WEST SUSSEX COUNTY COUNCIL CONSULTATION

TO:	Arun District Council FAO: Michael Eastham
FROM:	WSCC - Highway Authority
DATE:	12 August 2021
LOCATION:	Phase 5 Hampton Park Toddington Lane Littlehampton BN17 7PL
SUBJECT:	LU/206/21 Approval of reserved matters following outline consent LU/47/11/ for the development of 260 No. dwellings and the construction of the Central Spine Road running through Hampton Park. This site is in CIL zone SP2 and is not CIL Liable as strategic site.
DATE OF SITE VISIT:	n/a
RECOMMENDATION:	More Information Required
S106 CONTRIBUTION TOTAL:	SEE S106 AGREEMENT FOR OUTLINE PROPOSAL

PROPOSED SWALE TYPICAL CROSS SECTIONS

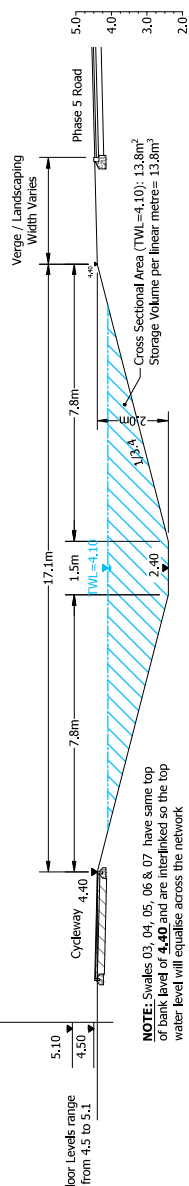
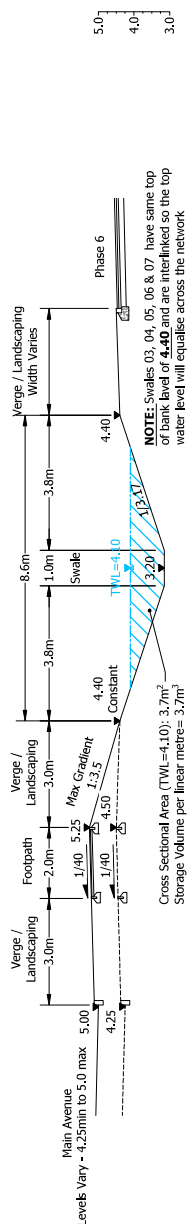
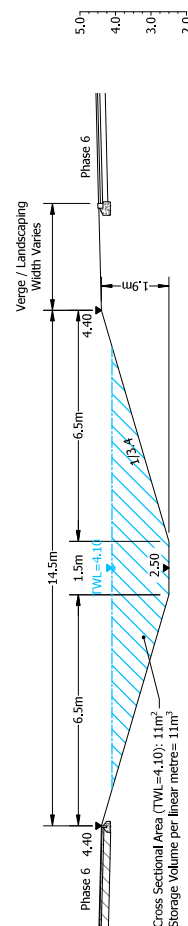
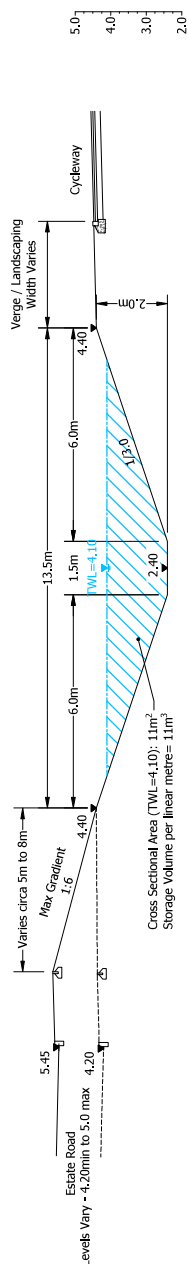
On the 'drainage strategy plan' drawing there are a number of culverts shown including the Bebo arch (ref: 1796). However, it's not clear what the function of all the culverts are. As such, it is not known which ones are to be offered for adoption and which ones are to remain private. Those under the roads being offered for adoption will need to be offered for adoption, whereas others may have to remain private. Nevertheless, their adoption status should be made known in the first instance.

Two of the culverts observed are shown to have an internal headroom of 1.0m. However, to be in compliance with CD 529 (i.e. min 1.2m) and irrespective of ownership status, the designer is legally obliged under the CDM Regs to consider inspection and maintenance. Therefore, 1.2m headroom will be required for all culverts throughout the development.
